Appeal Decision

Appeal Ref: APP/R5510/W/22/3300925

12 Whitethorn Avenue, West Drayton UB7 8JX

- The appeal is made under section 78 of the Town and Country Planning Act 1990 against a refusal to grant planning permission.
 - The appeal is made by Mr Manj Madhar against the decision of the Council of the London Borough of Hillingdon.
 - The application Ref 10697/APP/2021/4279, dated 12 November 2021, was refused by notice dated 14 January 2022.
 - The development proposed is new 1 bedroom bungalow with new drop kerb for car parking and amenity space.
-

Image -01

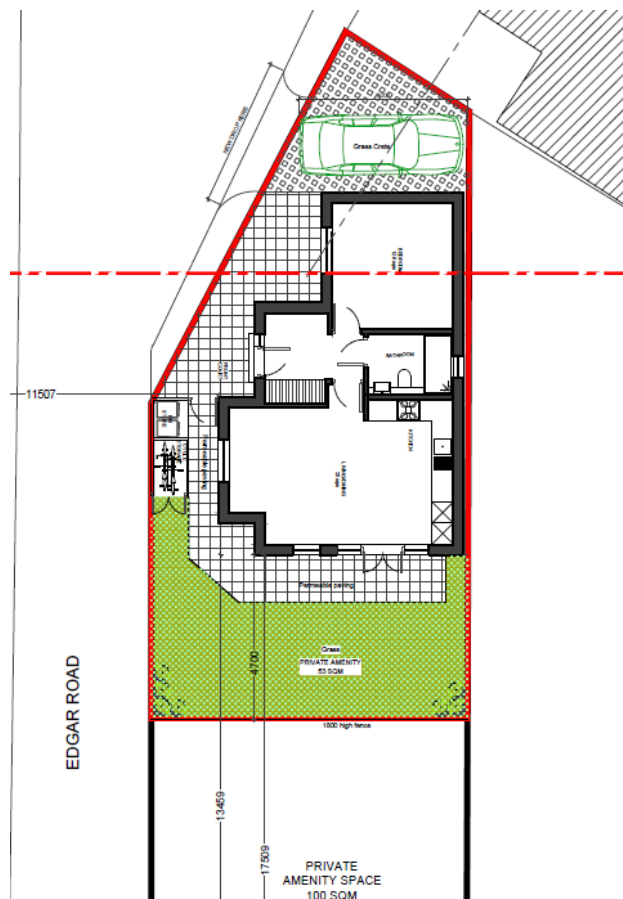
16. I agree that the window in the front elevation facing Edgar Road would have a very poor outlook due to the proximity of the bin/cycle store and boundary fence. However, this is only a secondary window. The main source of outlook and light to the kitchen/living room would be from the large full-height openings in the side elevation, which would face onto the garden area. Given the number and size of these openings, and the separation distance to the rear elevation of No 12, I am content that this room would benefit from a satisfactory open and light outlook, notwithstanding the proximity of the proposed boundary fence with No 12. It is also relevant that the dwelling would not be single aspect.
